Application by Mallard Pass Solar Farm Limited for an Order Granting Development Consent for Mallard Pass Solar Project- EN010127

Submission by John Hughes: ID ref: 20036141

Deadline 1 Written Submission on OFH 1 meeting 17<sup>th</sup> May 2022

Figure 6.8.1: Photograph Panel 1 (Centre)  
Representative Viewpoint 1

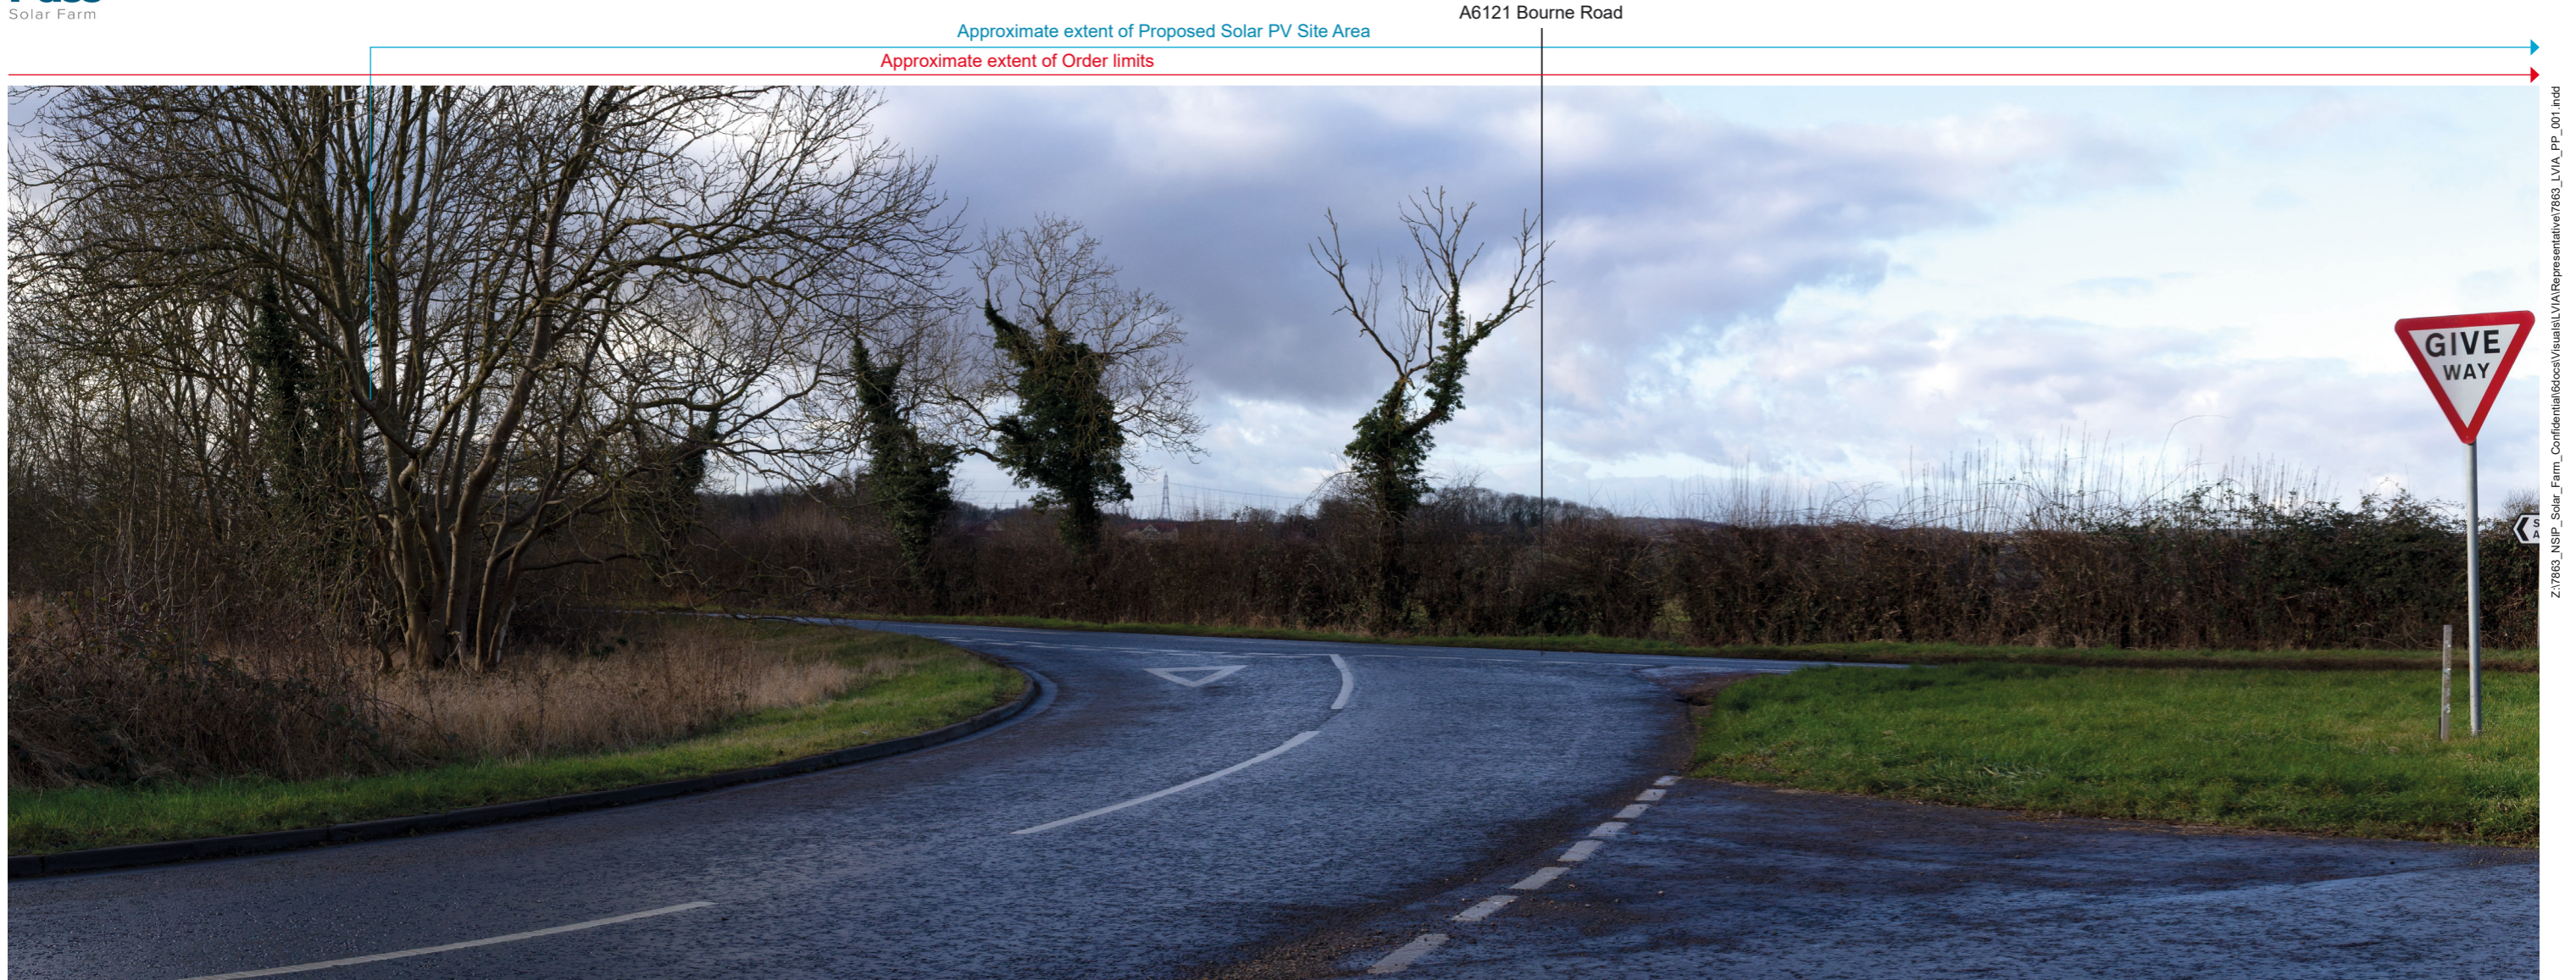
This view point is representative of motorist just meters from a road junction, the location does not represent the view from a footpath, bridleway, property or village with the field in the fore ground is not part of the proposed project and over 2km away from the proposed substation. The dense shrubbery on the left viewpoint hides the openness beyond the old railway line.

This VP has been used for a photomontage to represent the visual impact for the proposed substation and PV arrays, however motorist will not have time to judge this view point as they will be concentrating on negotiating the road junction.

- Q. What determined the location and selection of this VP?
- Q. Why was VP not selected on the opposite site of the disused railway line further along the road?
- Q. Why was this VP selected to be used as a photomontage?
- Q. Will Cumulative wire line imagery be made available?
- Q. Does the VP give a legitimate representation of what is being proposed?

The Ryhall substation and pylon are in line so the photomontage Yr1 below does not signify the size of the new substation its protrusion east/west or elevation into the landscape/horizon, the VP uses the current substation and distant horizon to mask the visual impact from within the village of Essendine

The Yr 15 photomontage shows the substation still visible on land higher than the current industrial buildings which are east of the ECML in Essendine.

Q. What is the purpose of the Location and what is the photomontage trying to present?
